Application for Planning Permission for Works or Extension to a Dwelling

Development: Install a 1kW Solar Panel Array at 1st floor level to the wall on the side of my house. These have already been installed for a few years now & I was under the impression that planning permission was not required as the installation was covered under "Permitted Development".

Location: 1 Arlington Crescent East Preston BN16 1DL

1 ARLINGTON CRESCENT

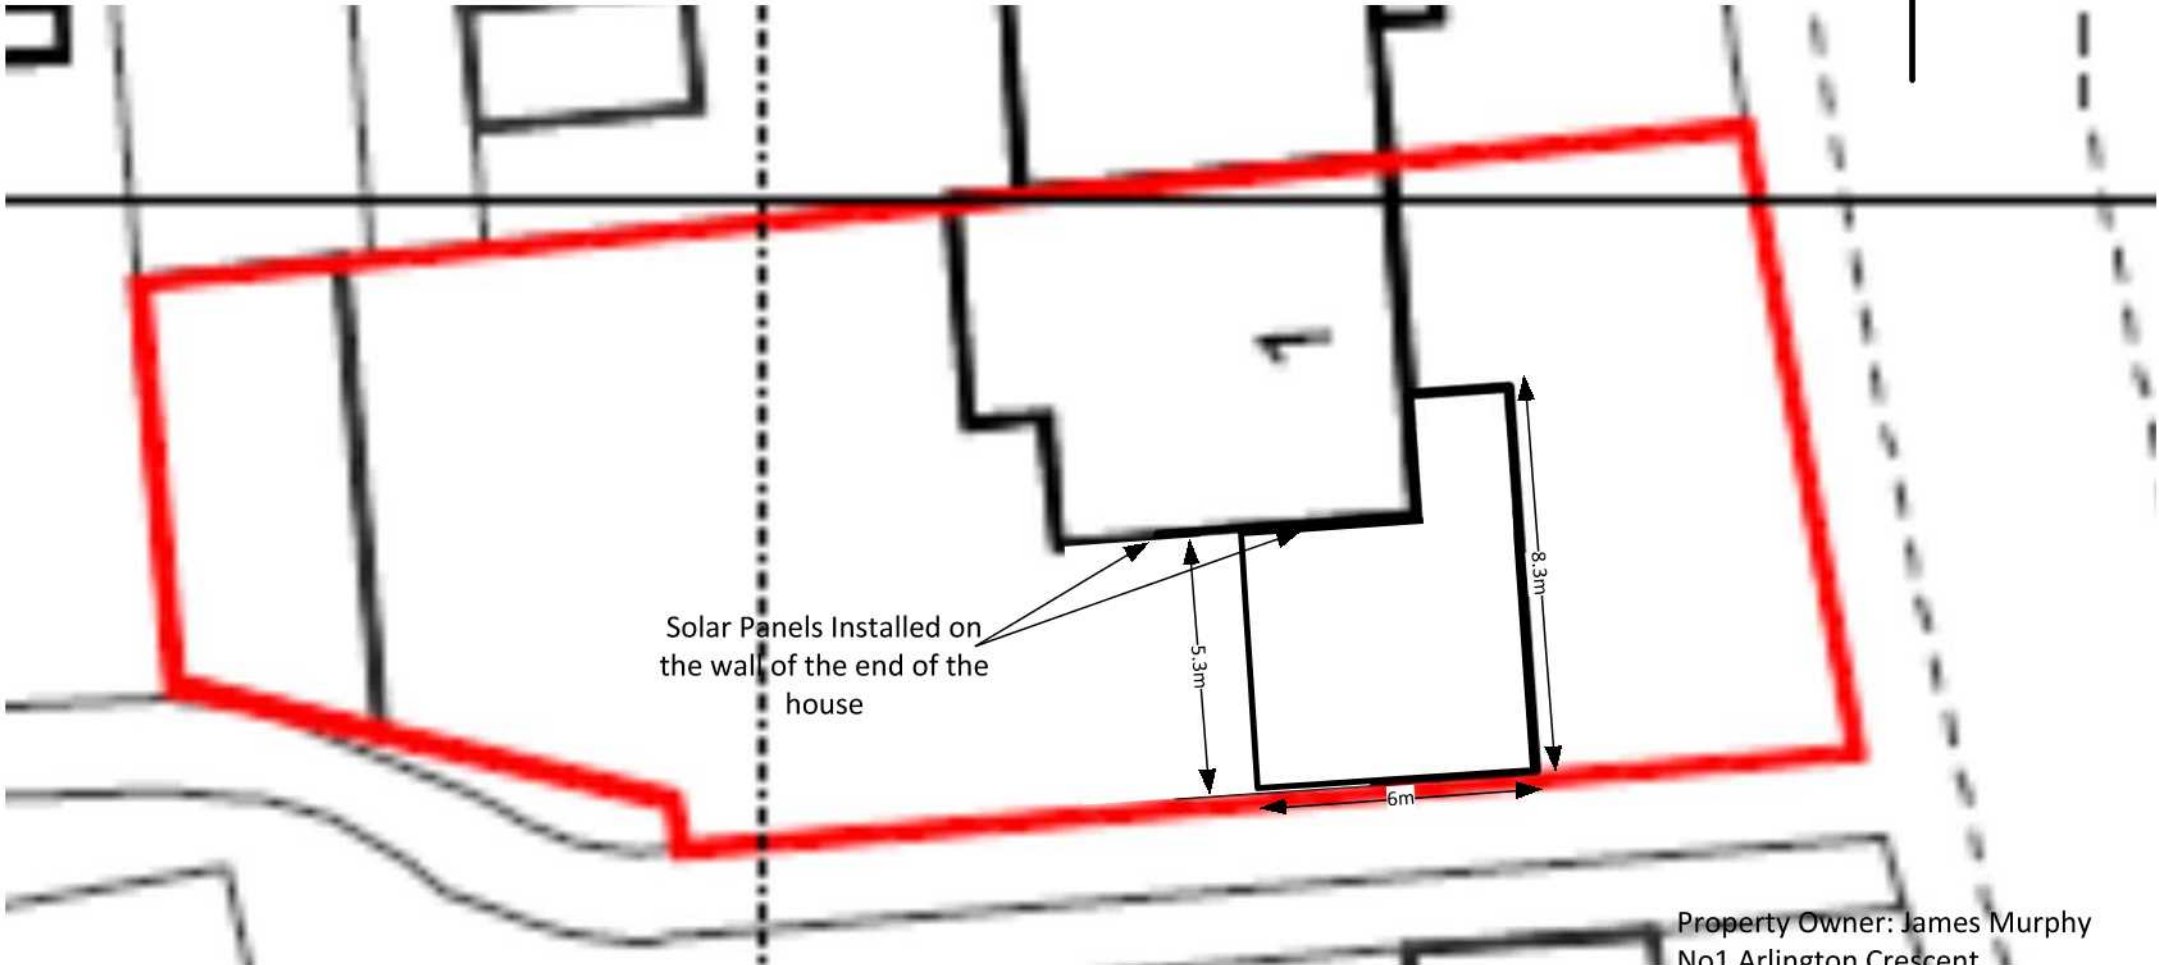
Block Plan: Please include a dimension on the block plan from the solar panel to the site boundary.
